Recommendation Report for Planning Permission for Works or Extension to a Dwelling

REF NO: AW/215/25/HH

LOCATION: 20 Aldbourne Drive
Aldwick
PO21 4NE

PROPOSAL: Proposed demolition of conservatory and detached garage. Proposed single storey side extension.

Proposed Ground Floor Plan 1:50

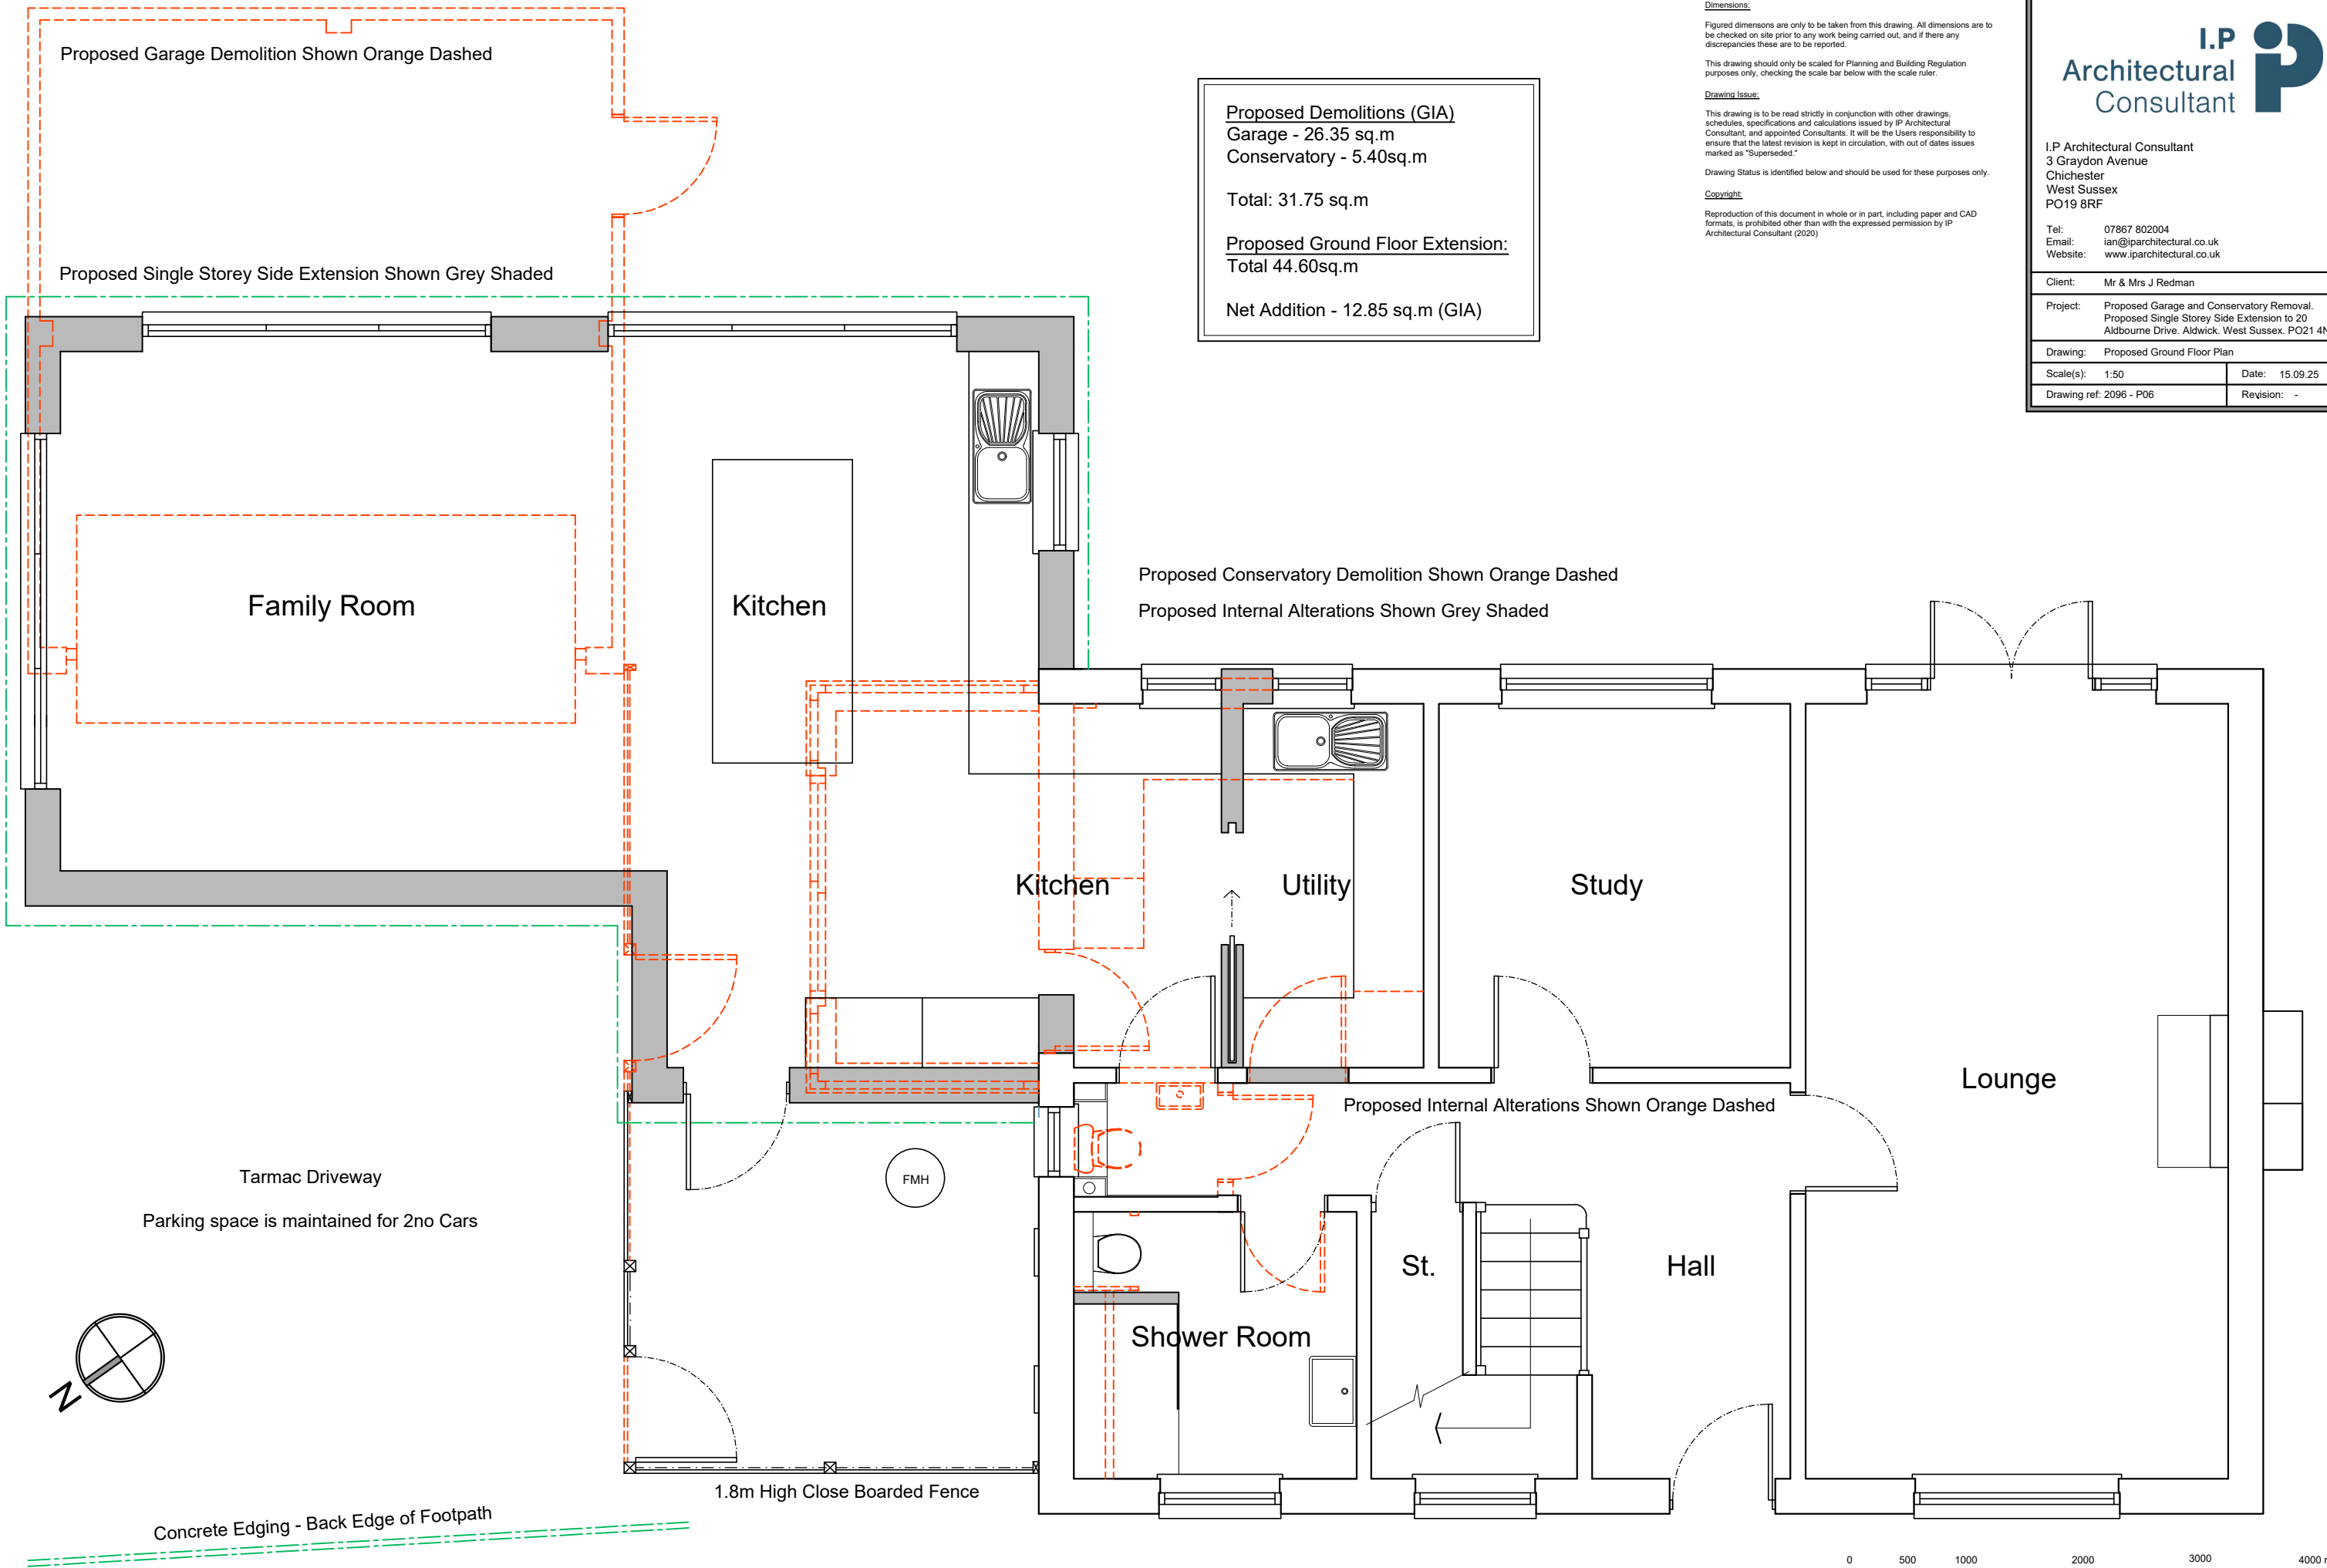
The extension would consist of two sections, a flat-roofed section measuring approximately 3.5m in width and a pitched-roof section measuring approximately 5.2m in width. The overall depth would range from approximately 6.7m at its deepest point to 5m. The pitched roof section would be finished with clay roof tiles, while the adjoining flat-roof section would feature a felt roof. The maximum height of the pitched roof section would be approximately 4.9m, and the flat-roof section would measure approximately 3.2m.

The extension would be set back 3.5m from the front (north western) elevation of the host dwelling and would be positioned approximately 11m from the side (north eastern) boundary, in accordance with Section M of the Arun Design Guide.

Fenestration would include bifolding doors on the rear (south eastern) elevation and a door within the front elevation, partially screened by an existing 1.8m high close-boarded fence. The extension would be finished in materials to match the host dwelling.

Proposed Elevations 1:100

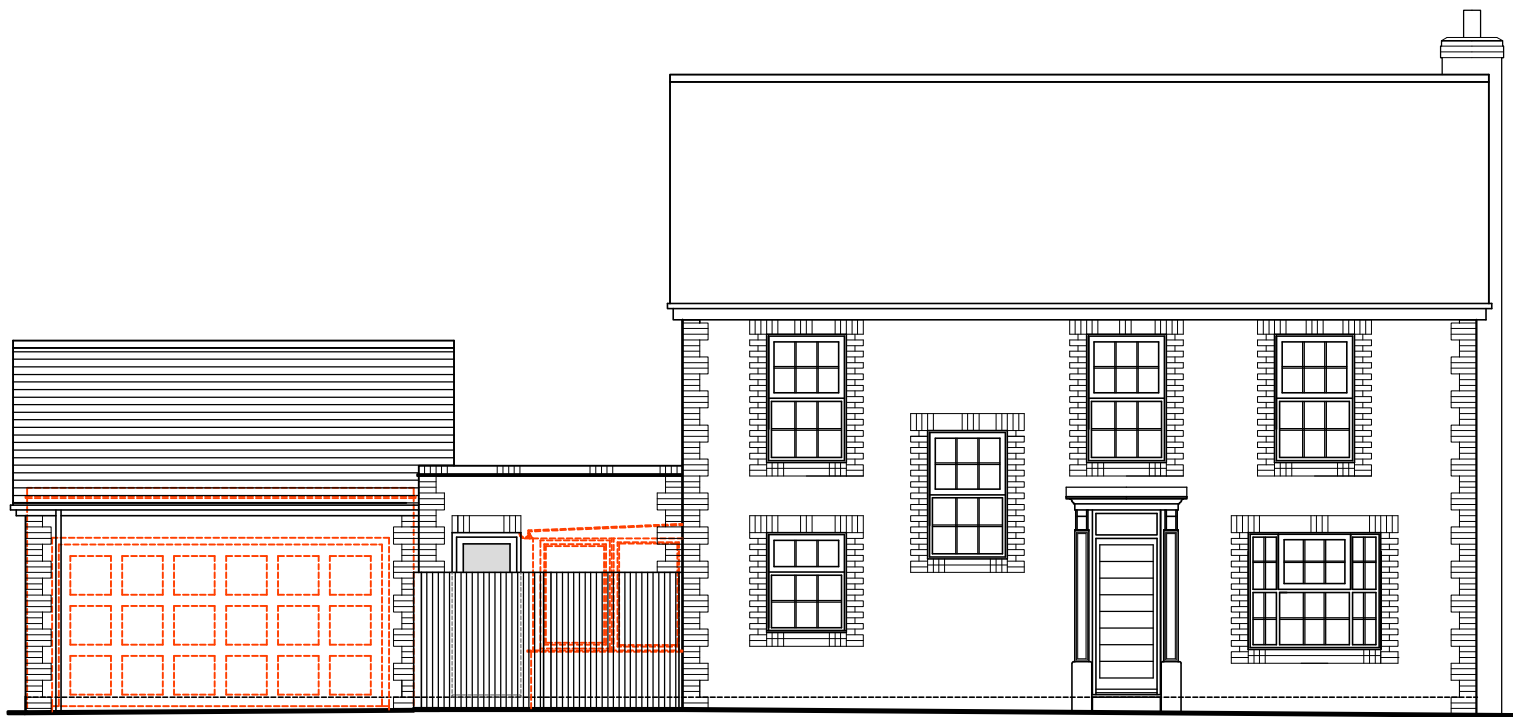
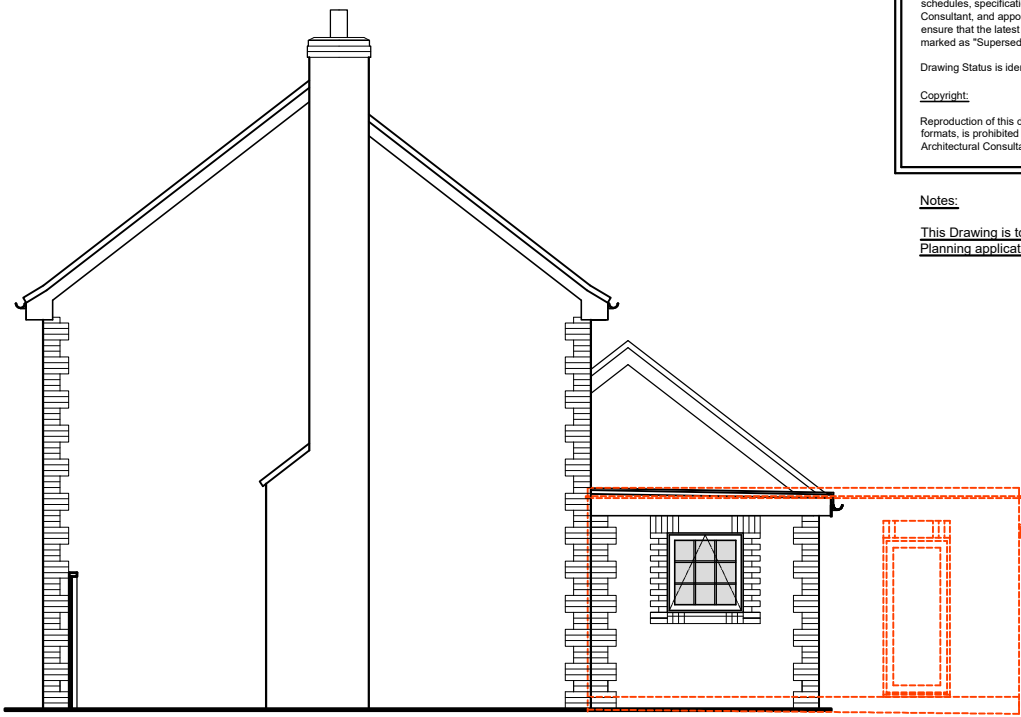
While the proposed scale and massing would not appear visually subservient to the host dwelling, the design would not adversely impact the street scene. This is due to the presence of the existing garage of similar design, and the use of materials that match or closely resemble those of the host dwelling, in accordance with policy D DM4 of the Arun Local Plan.
